# Rezoning Transportation Analysis

Petition Number: Insert Zoning Petition #2022-031

**From:** Jake Carpenter, PE

Date	Description
07-26-22	First Review (TM)
08-23-22	Second Review (WB)
08-26-22	Third Review (JC)

**RZ-1**

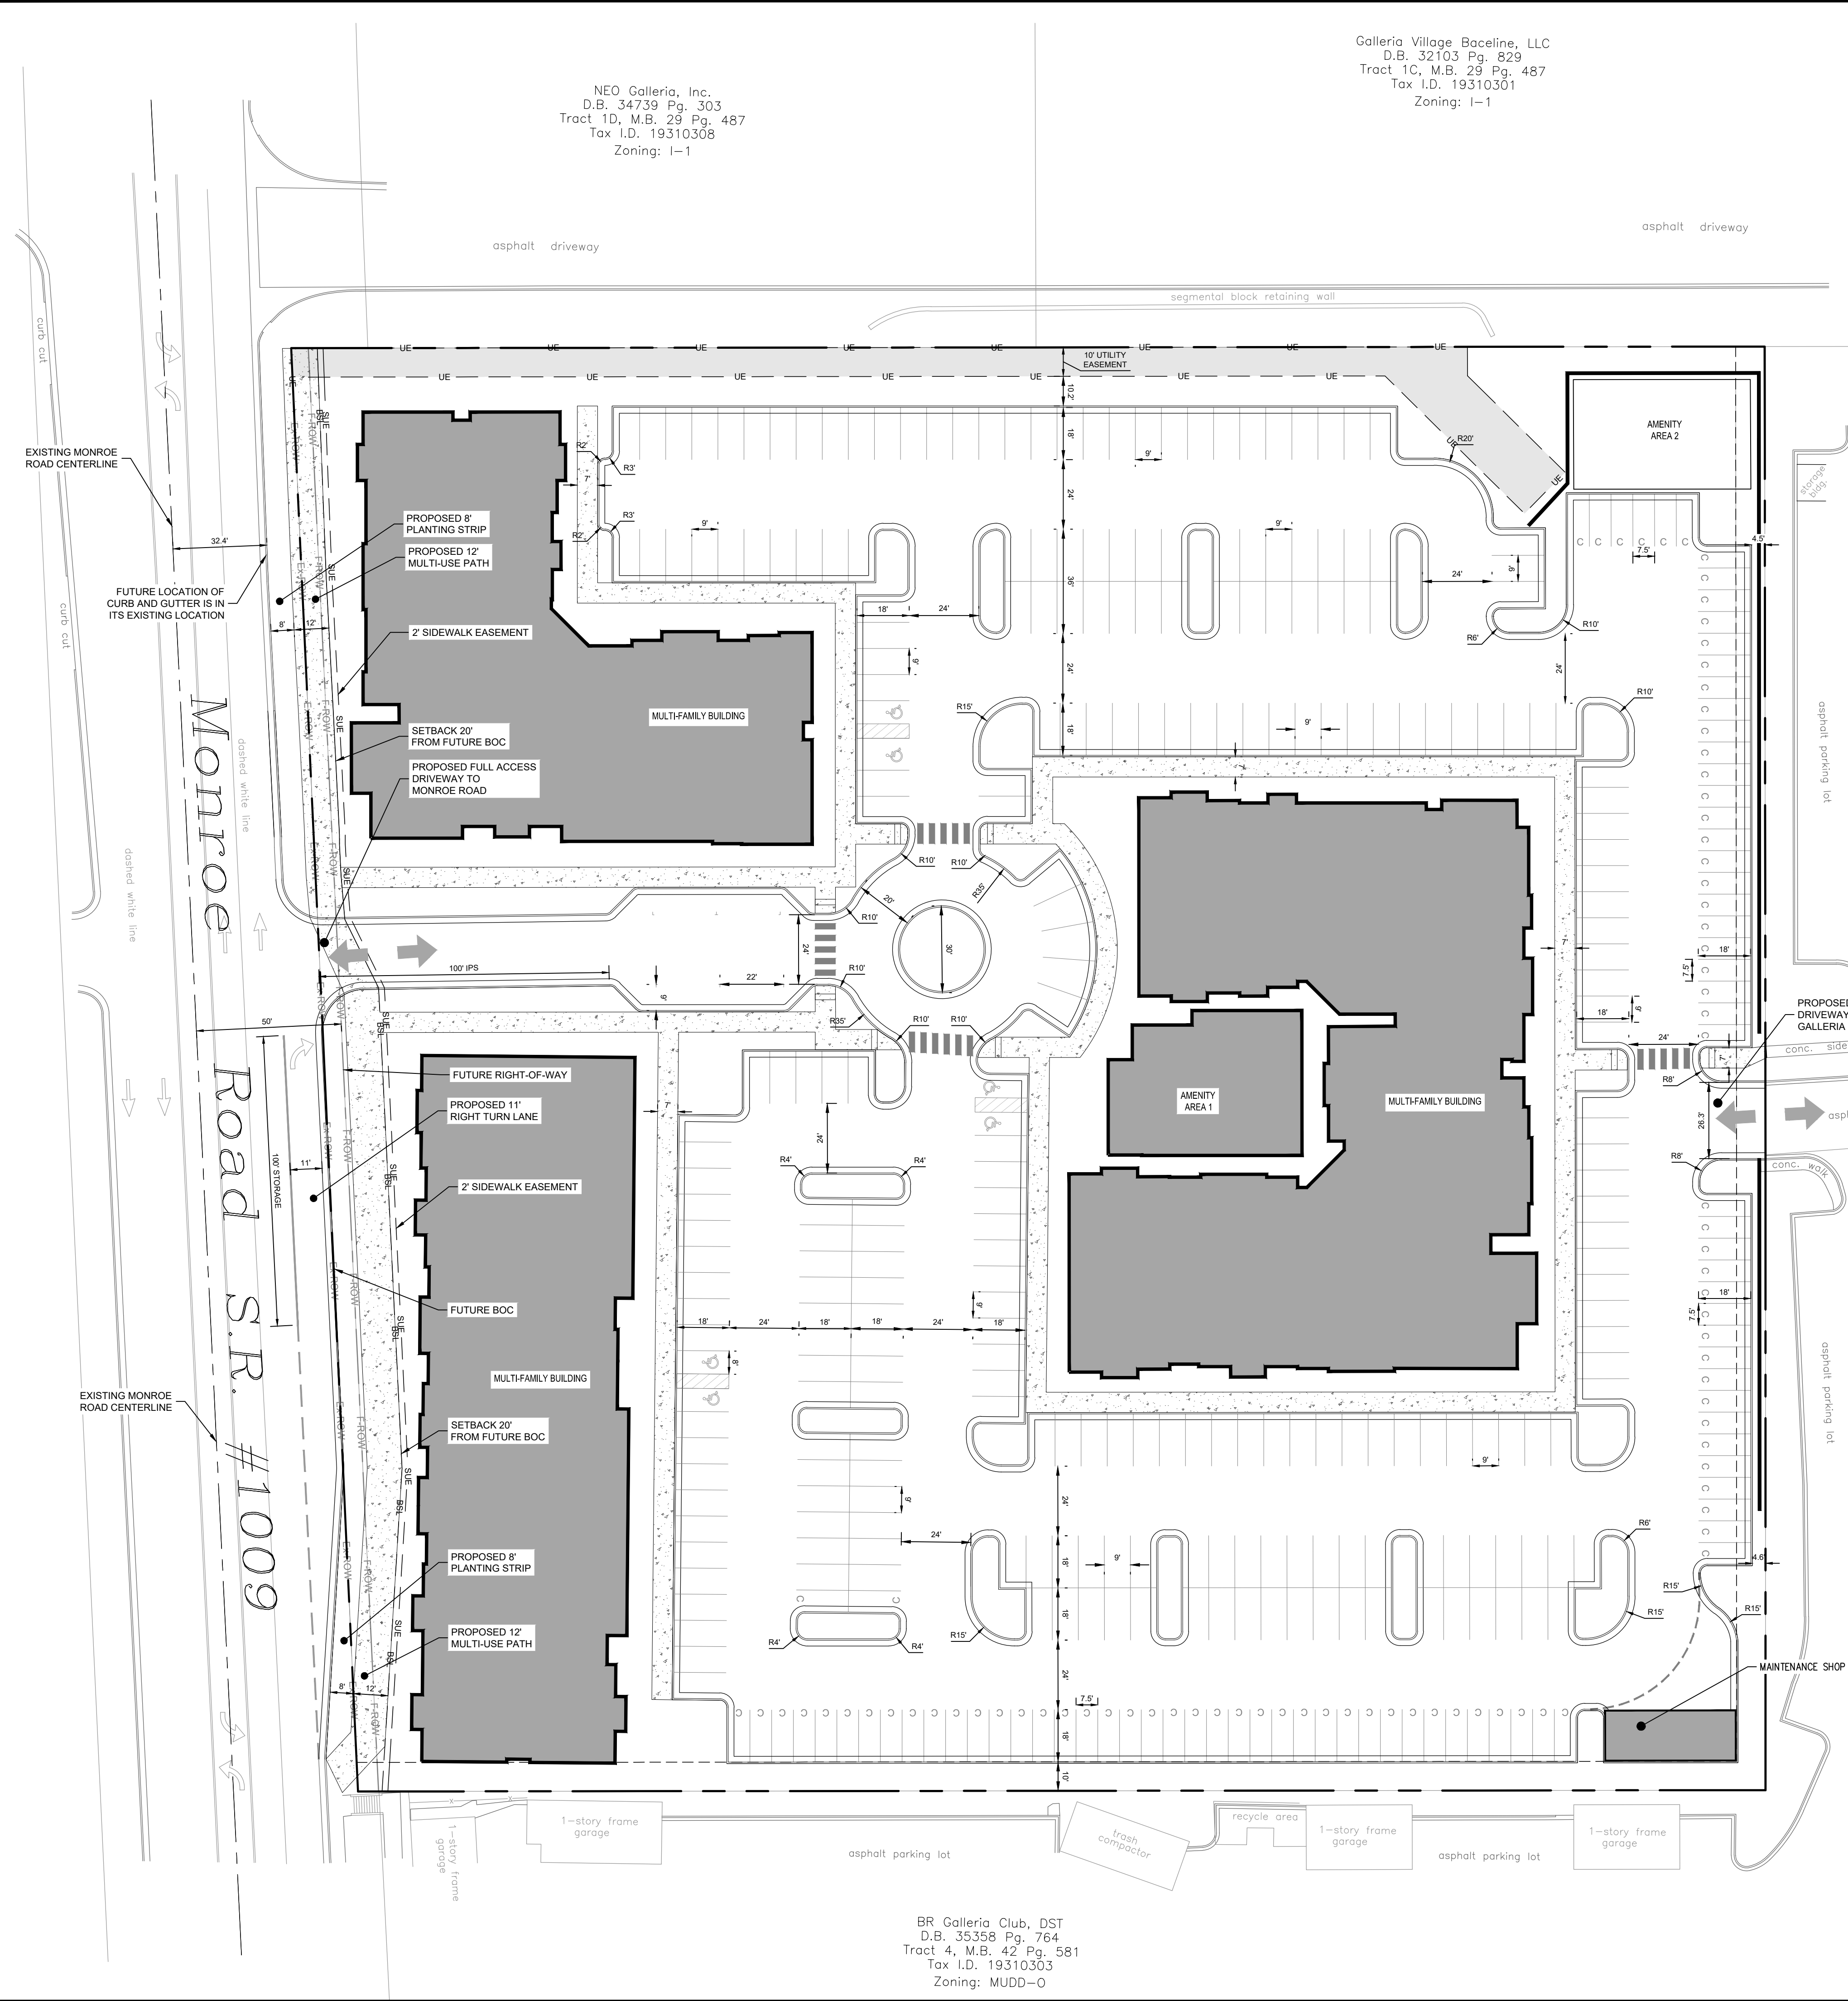
- ~~**CDOT REQUEST:** Revise site plan and conditional note(s) to provide a private street connecting Galleria Club Lane to Monroe Road.~~ **Comment Rescinded 8-26-22**

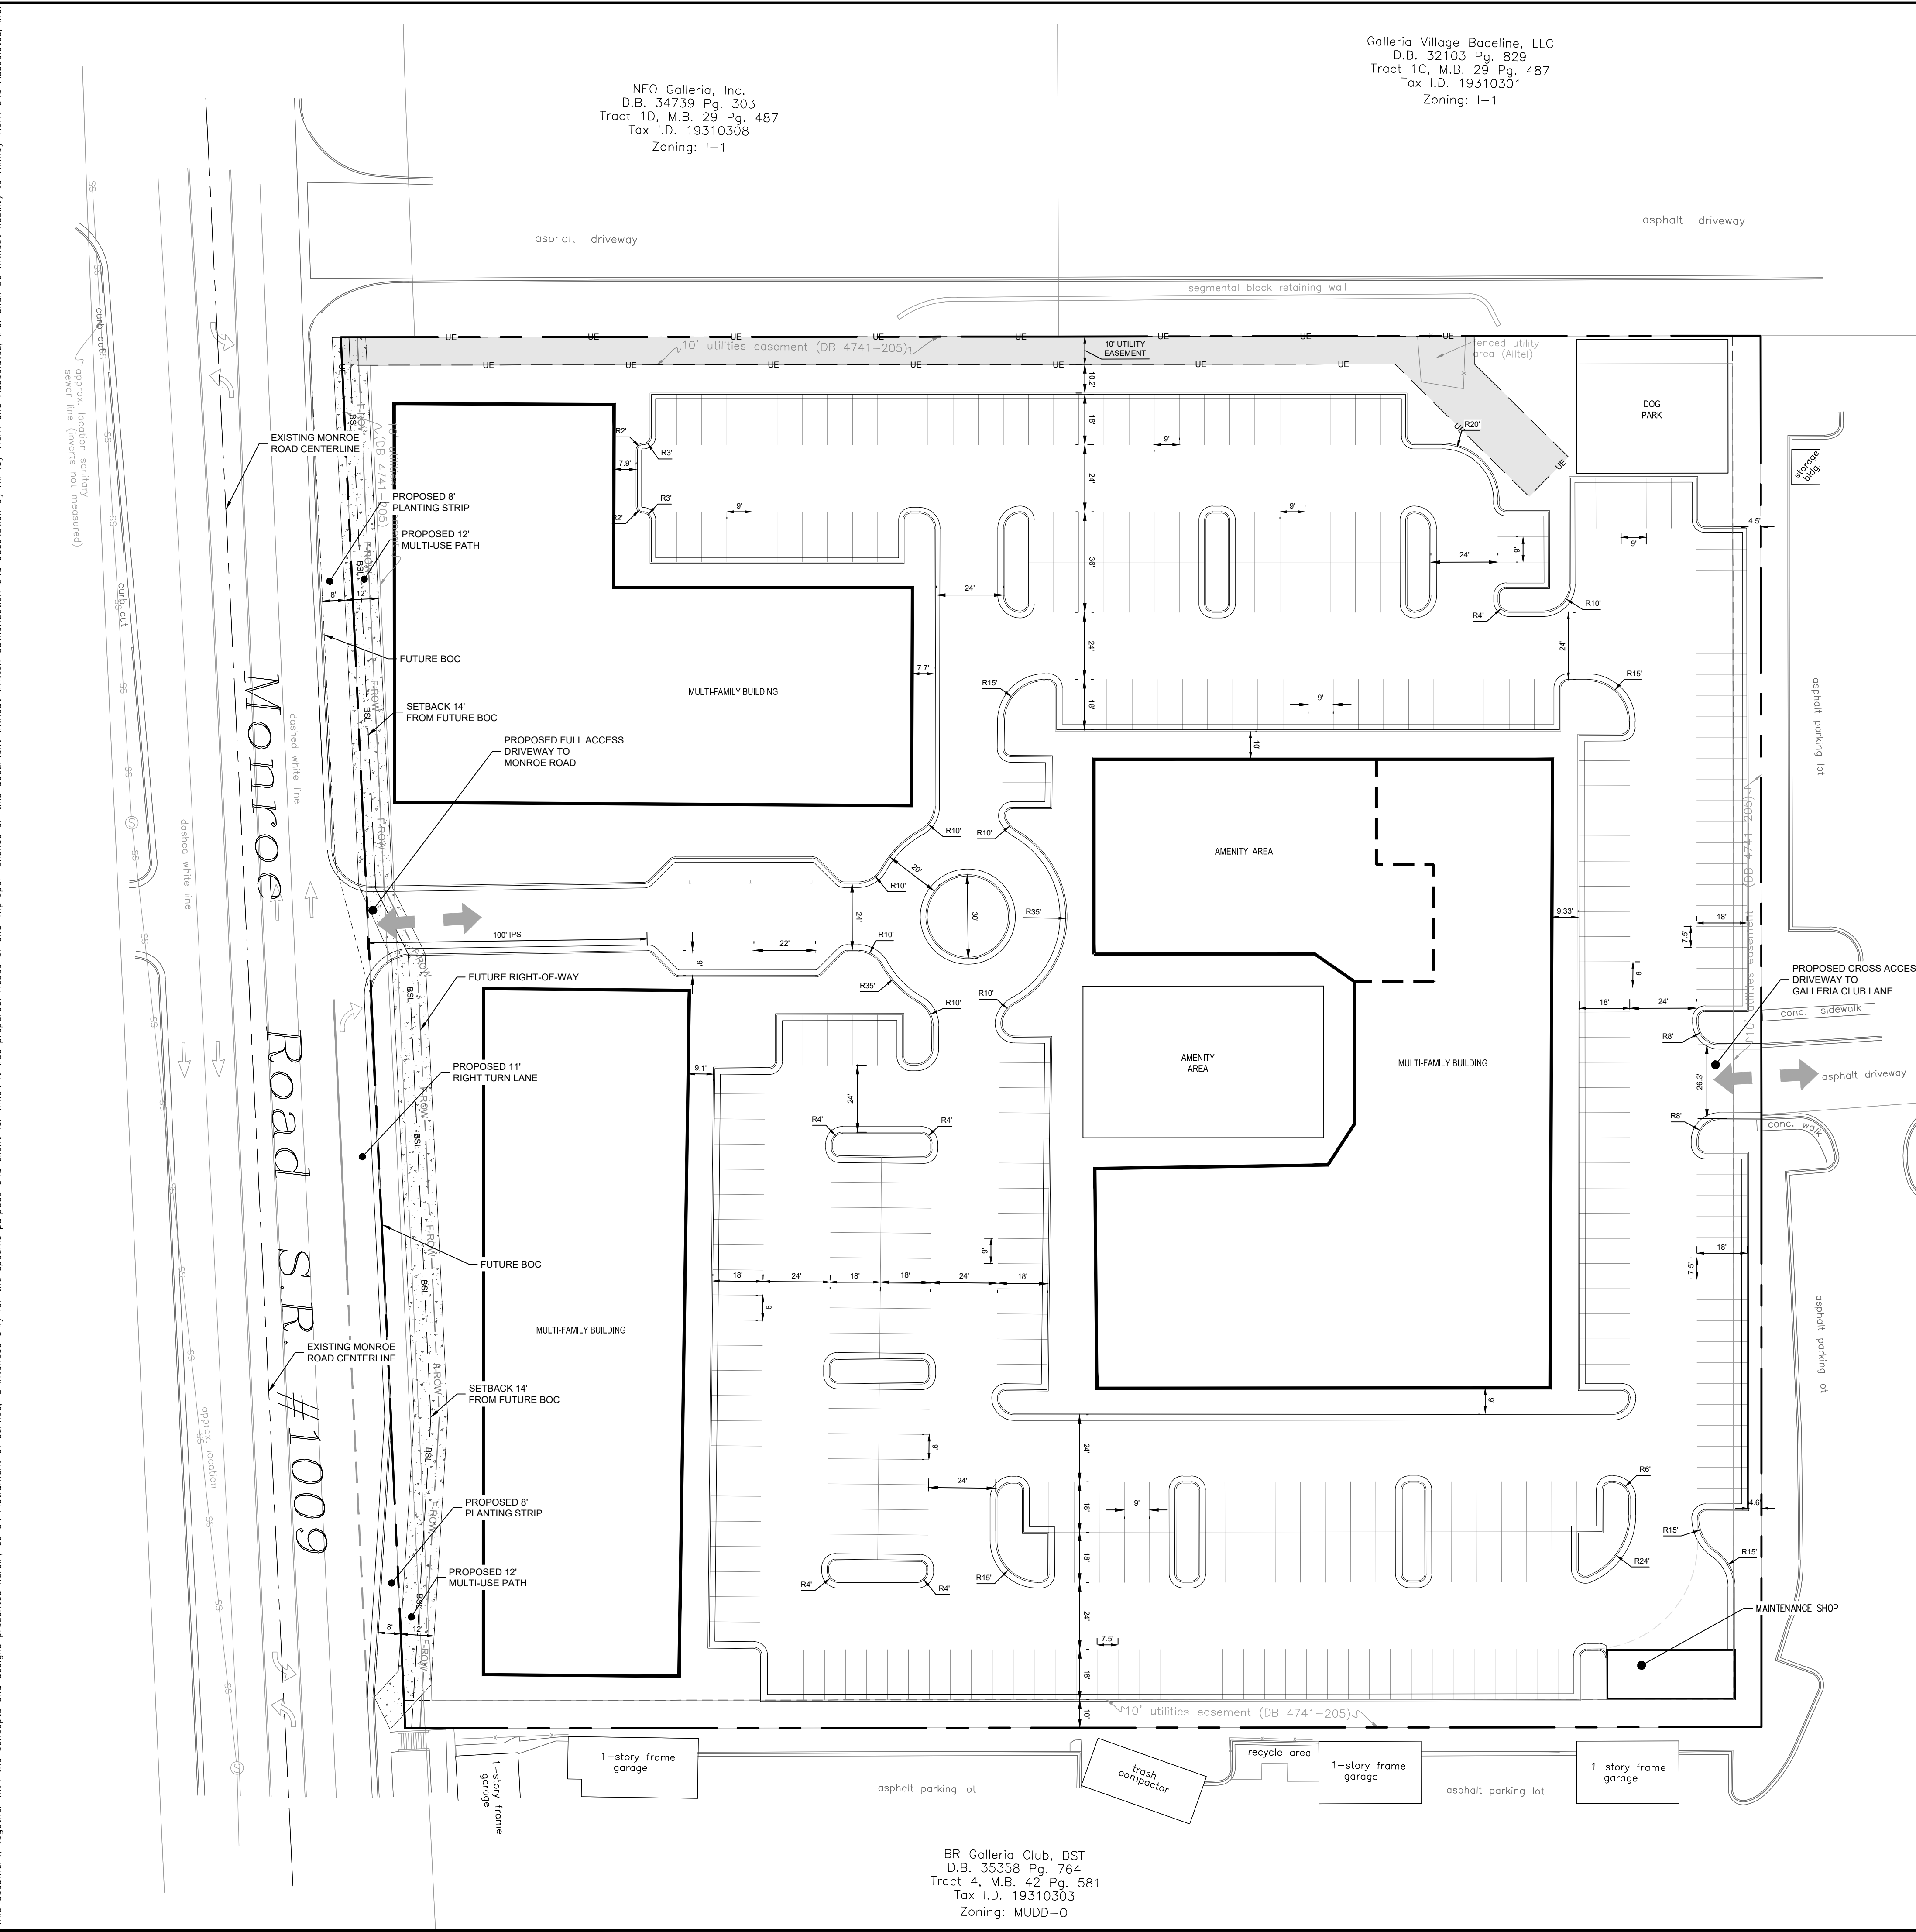
~~Label and dimension the curb and gutter from the centerline for each road on the site plan.~~
- ~~**Traffic Study:** A Traffic Impact Study (TIS) is not necessary for the complete review of this petition due to the site generating less than 2,500 daily trips. If during the permitting process the site generates more than 2,500 daily trips, then a traffic study will be required.~~

- ~~Site plan and conditional note(s) revisions are needed to provide a minimum of 100-foot of protected internal driveway stem at the proposed site access. The protected stem length should be dimensioned from the right of way on Monroe Road.~~

- ~~Site plan and conditional note(s) revisions are needed to commit to installing a right turn lane on Monroe Road with a minimum of 100-foot of storage per NCDOT coordination. Label and dimension right turn lane on site plan and add conditional note describing all turn lane design requirements.~~

- ~~6. A site plan note(s) specifying dedication and fee simple conveyance of all rights-of-way to the City before the site's first building certificate of occupancy is issued as needed. CDOT requests rights-of-way set at 2' behind back of sidewalk where feasible.~~

- ~~7. Site plan revisions are needed to provide sidewalk utility easement or ROW located 2-feet behind the 12-foot MUP on Monroe Road. Identify the SUE on the site plan.~~
